RIMINGTON & MIDDOP
PARISH COUNCIL

Response to planning application 3 2013 0597P
Alterations to the Black Bull

Existing and Proposed Site plans

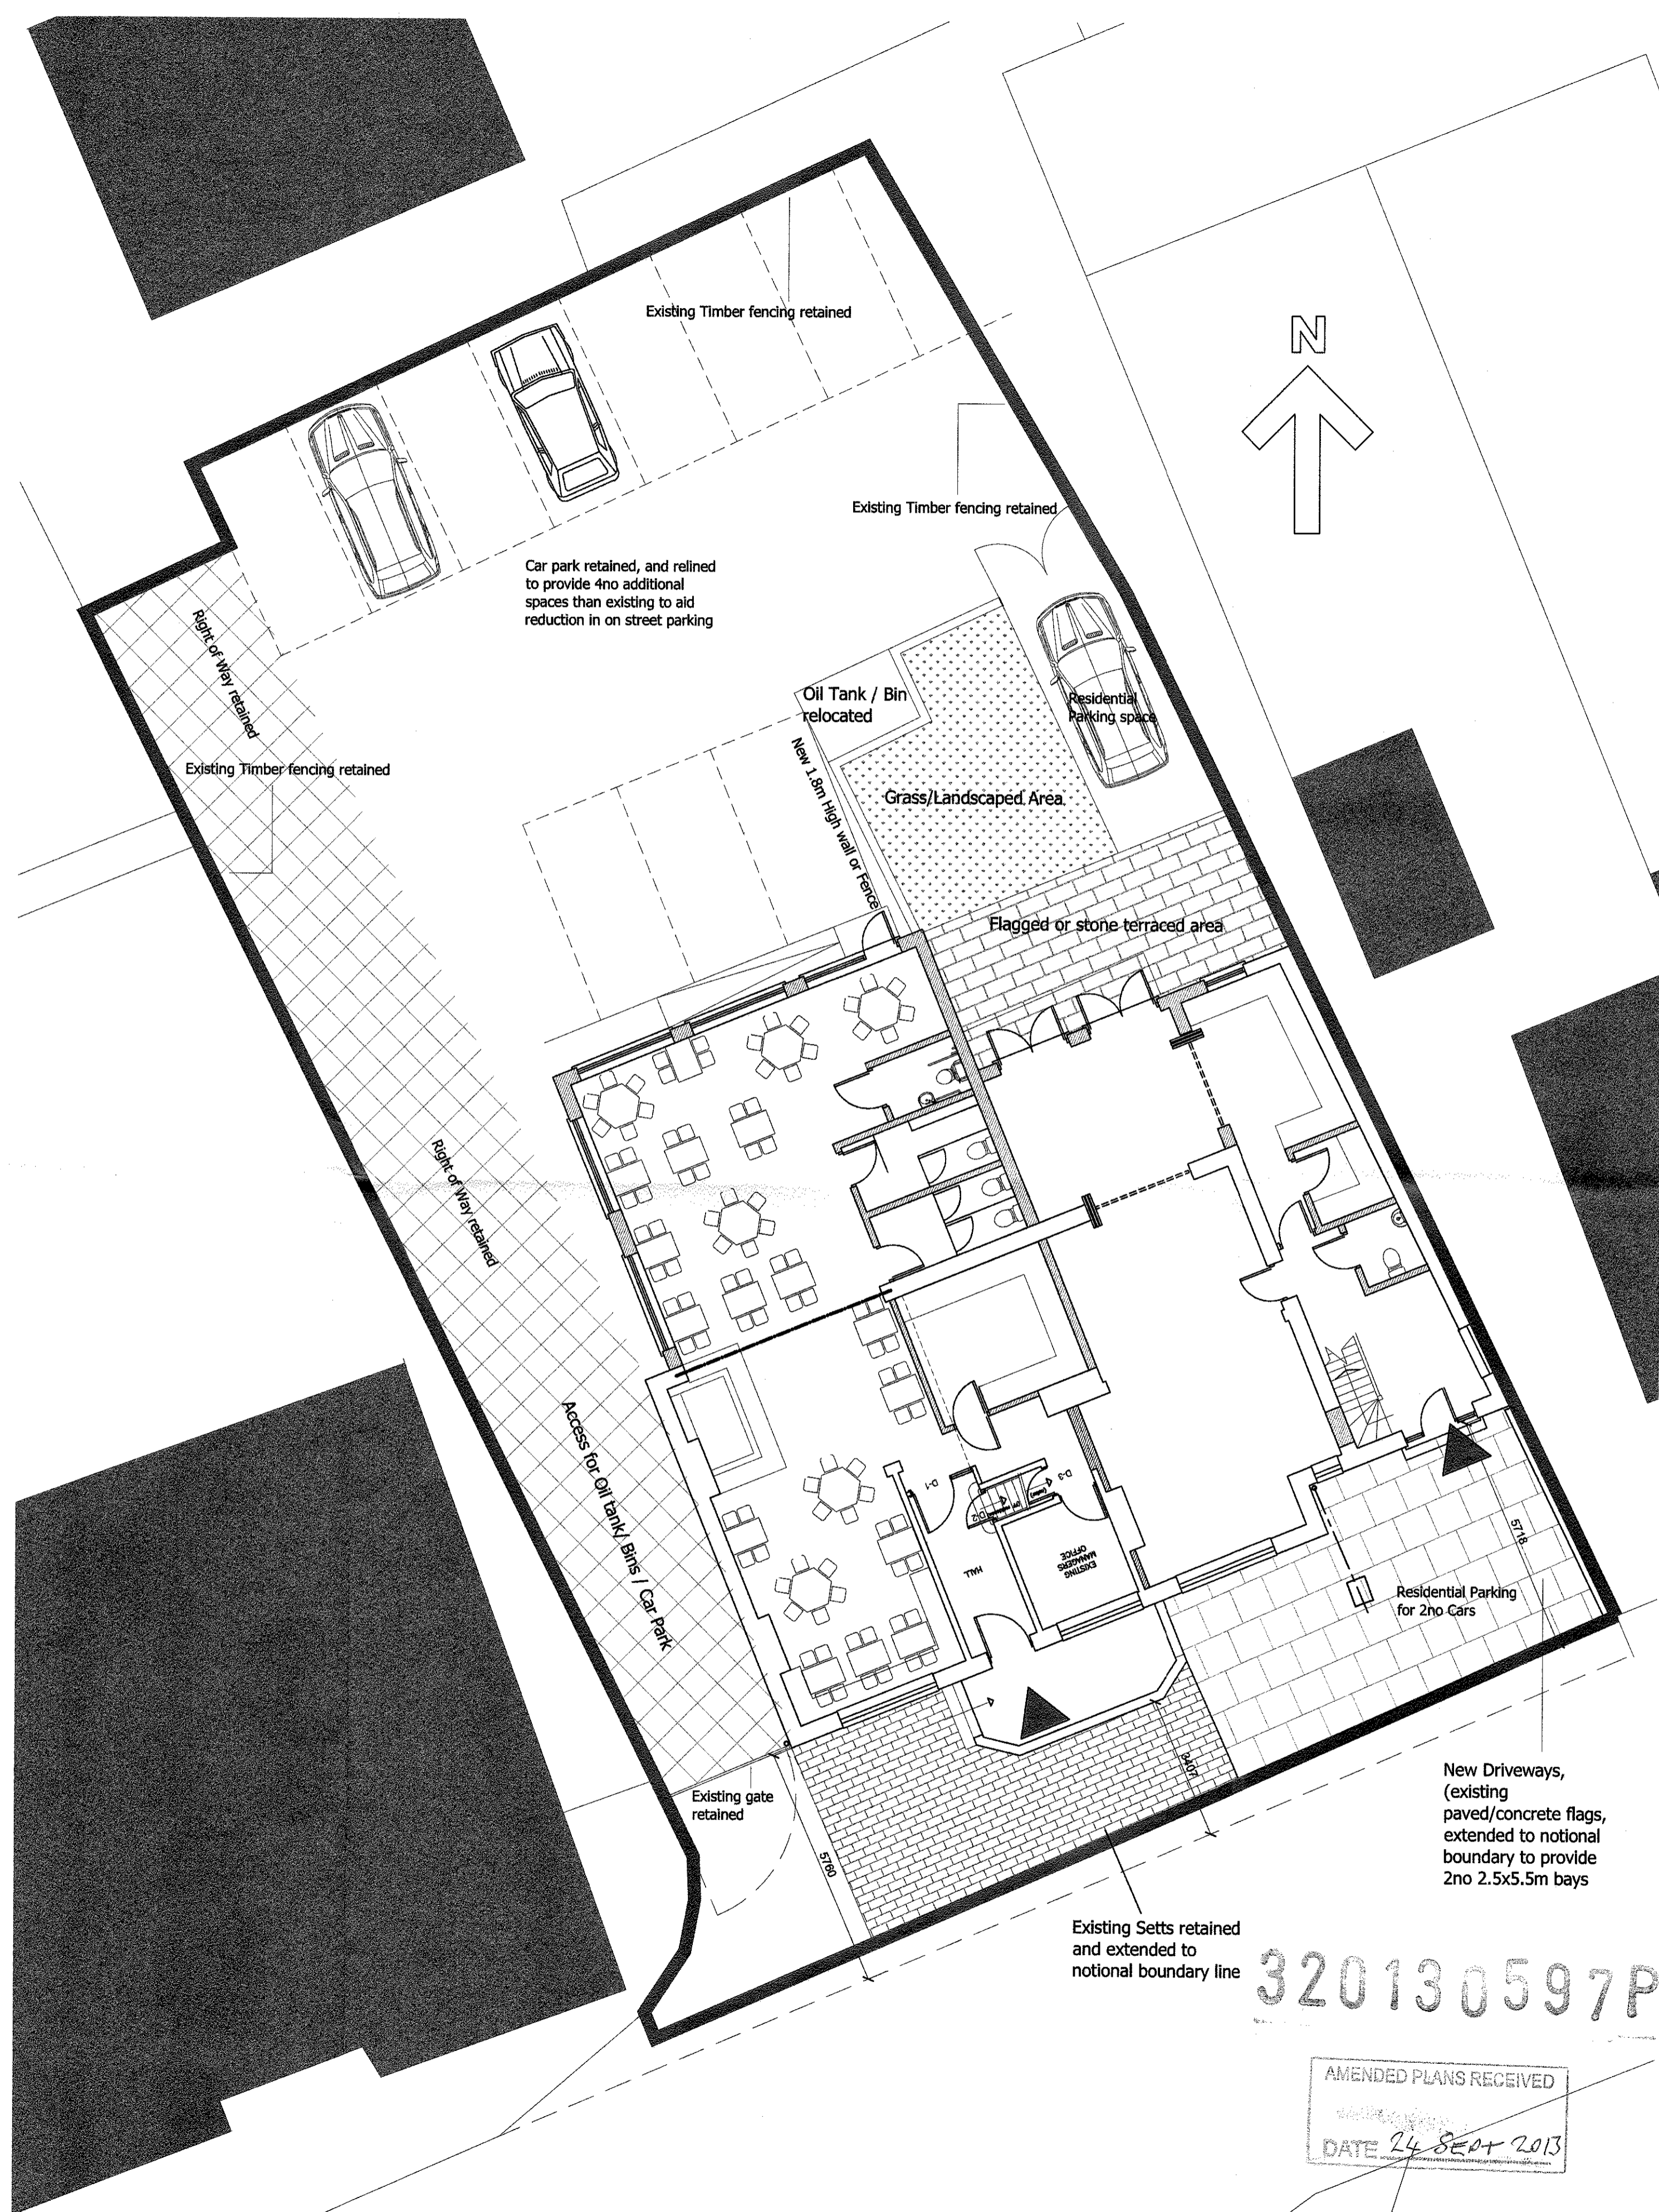
They had one concern over a detail missing from the plans. There is a footpath which starts on the parking on east side of the front of the pub and passes through a snicket in the boundary wall onto the side of the drive belonging to Woodview. It then passes to Back Lane. This path is quite heavily used and they would not want the change from Pub to private parking to interfere with its use.
